CITY OF ALBUQUERQUE

July 24, 2024

Re: Element Hotel
2440 Louisiana Blvd. NE
30-Day Temporary Certificate of Occupancy
Transportation Development Final Inspection
Architect's Stamp dated 03-13-20 (H19-D087)
Certification dated 07-16-24

A1.2

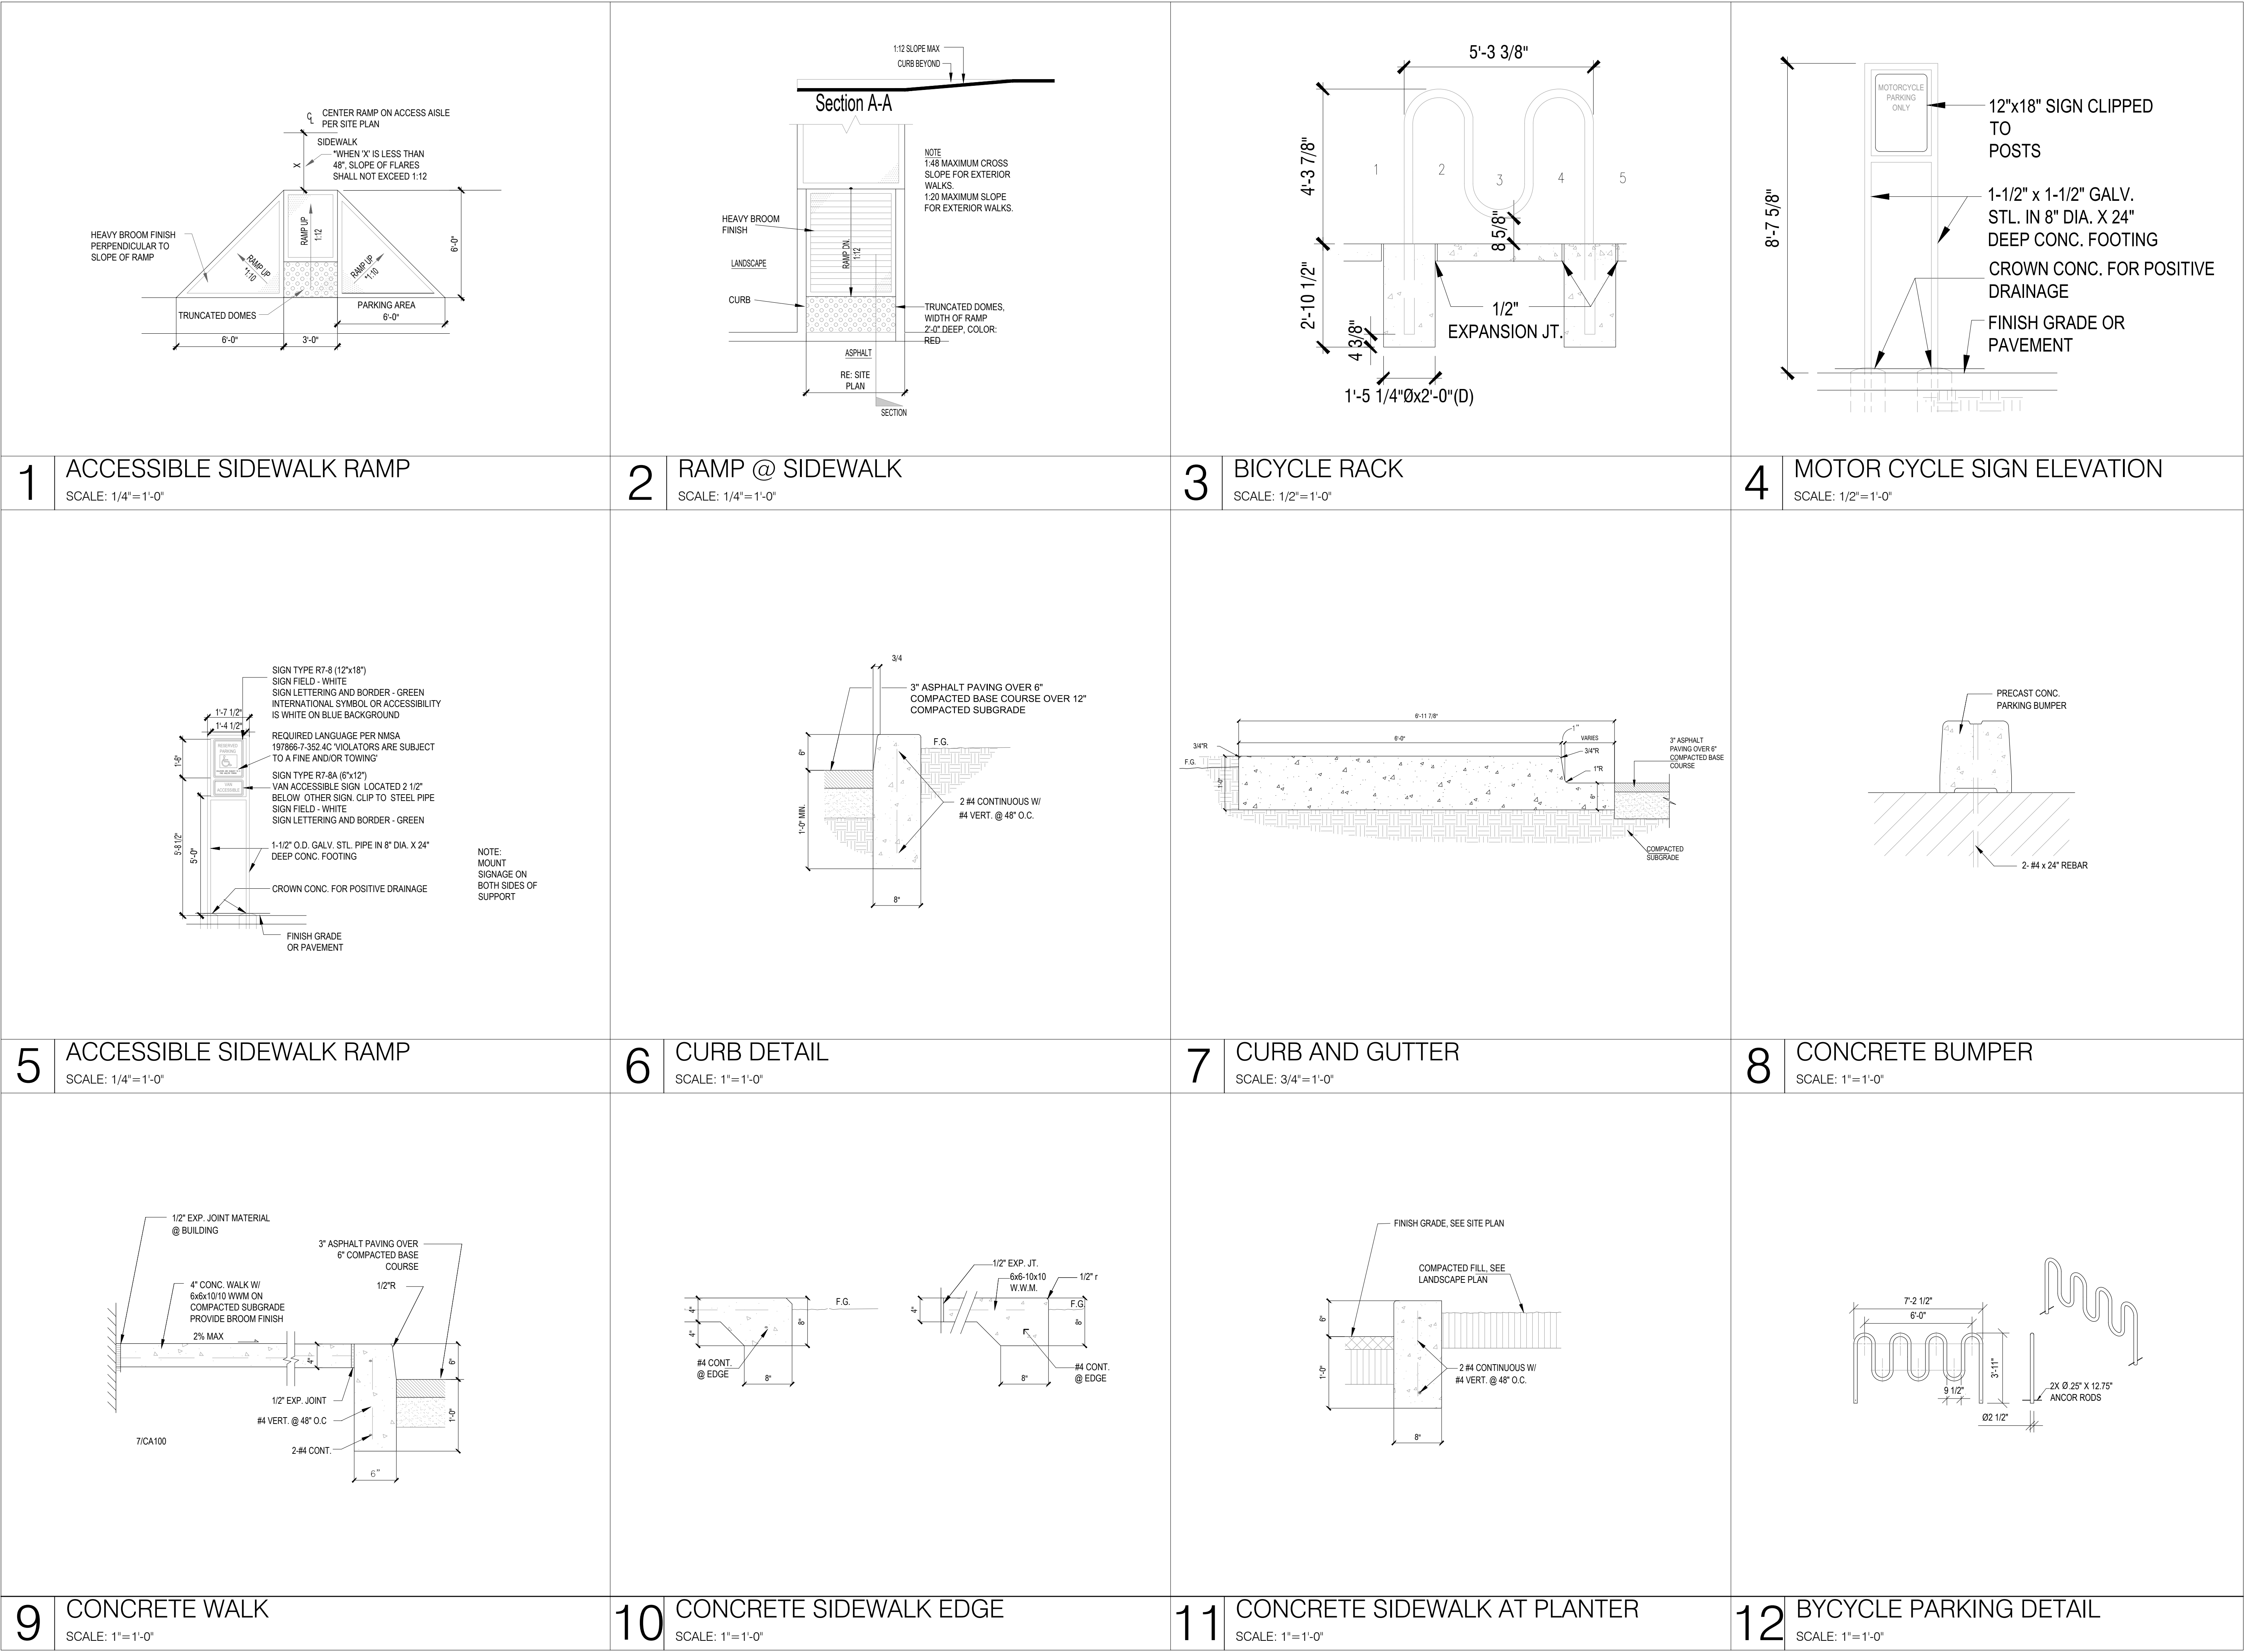
- Per the approved site plan, please anchor down the Bike Rack.

Once these corrections are complete, email pictures to malnajira@cabq.gov for release of Final CO.
